PLANNING AMENDMENT

APPLICANT NAME AND ADDRESS MRS D GIESSLER 5, LOWGATE LANE SURFLEET NR. SPALDING, LINCS PE114AS Telephone:	AGENT NAME AND ADDRESS Telephone:
SITE ADDRESS DETAILS 5, LOWGATE LANE, SURFLEET, NR. SPALDING, LINCS. PE114AS	
CURRENT APPLICATION NO: This amendment cannot be considered unless the relevant reference is stated.	H17-0575-20
Building Regulation reference relating to same development (if applicable)	B17-1143-16

OCT 2019 - 1:100, 1:50 & 1:1250 @ A2 - PLANNING DRAWING - GG/01 A

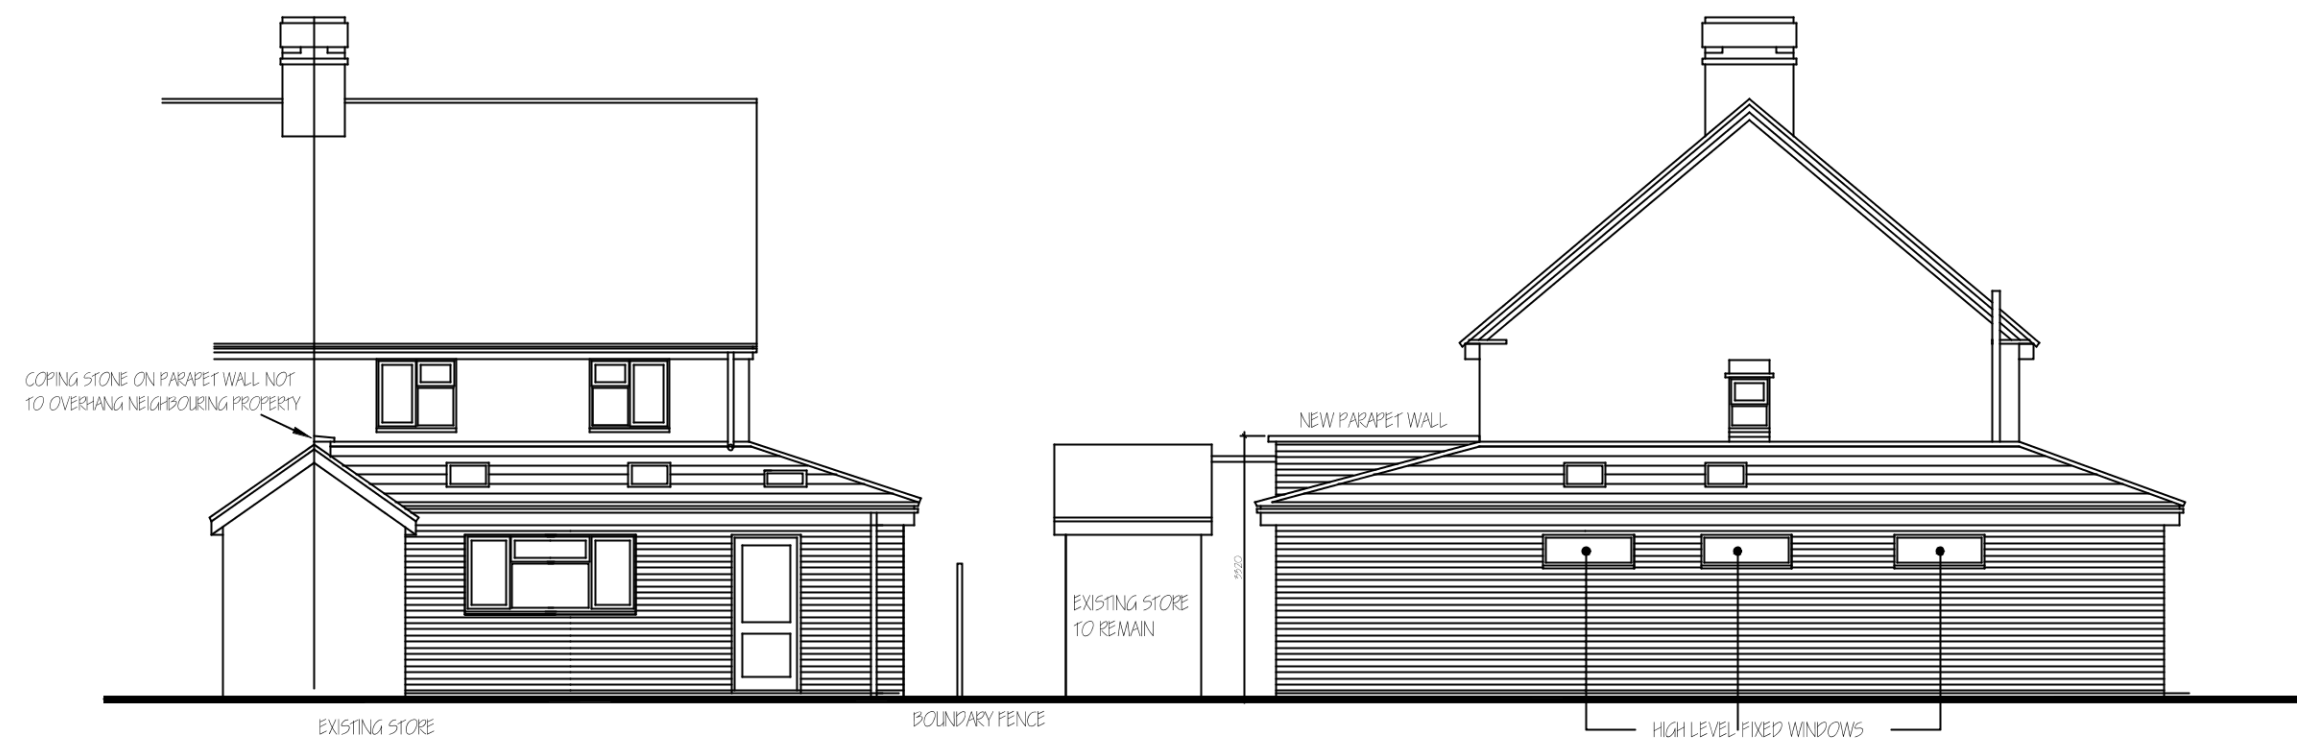
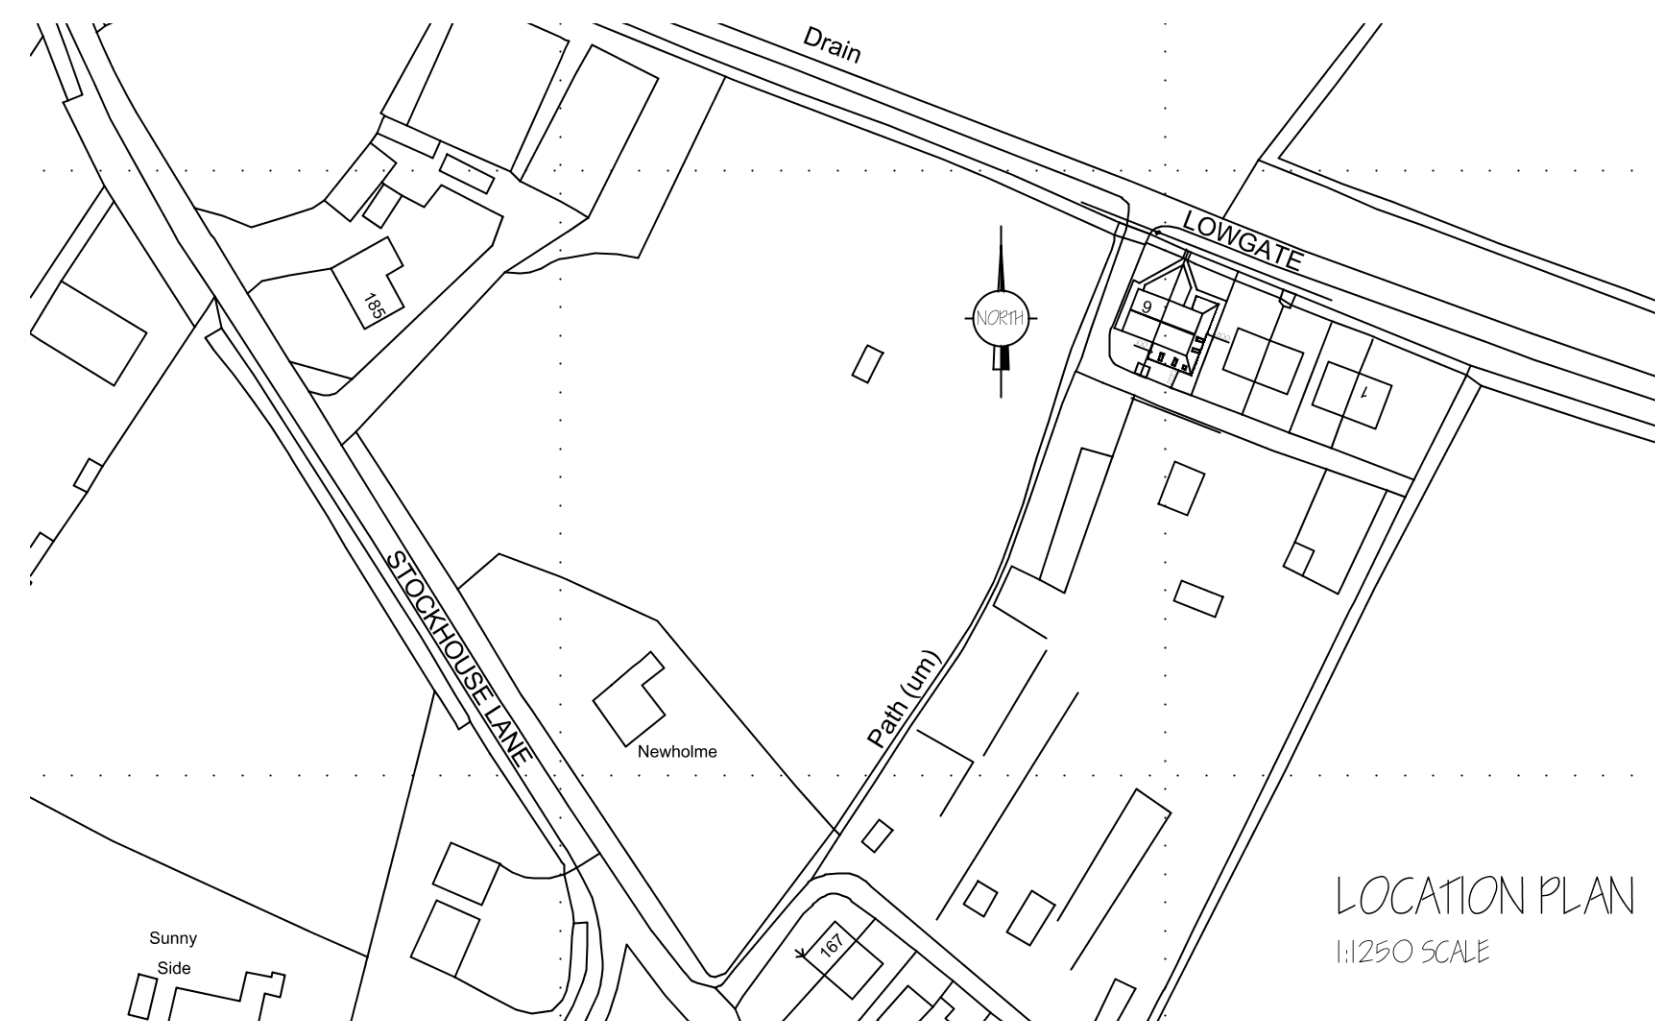
FULL DESCRIPTION OF DEVELOPMENT OF CURRENT APPLICATION THAT THIS AMENDMENT RELATES TO		
State details of amendments proposed. (Give a full detailed list of the changes, and also mark these clearly on the accompanying plans. Only the changes listed here will be considered)	PARAPET COPING STONE CHANGED SO THAT DOES NOT OVERHANG NEIGHBOURS AT NO. 6, LOWGATE LANE.	
State drawing numbers of the current submission	GG 01 REV A	
Has this amendment been requested by the Council? (If so, state Officer dealing with the application)	YES/NO	DAVID GRANT
Describe any part of the original development which is excluded by virtue of the amendment, and state any alteration to plot numbers		
Has a similar amendment been submitted under Building Regulations? (If so, state Building Control Surveyor dealing with application)	YES/NO
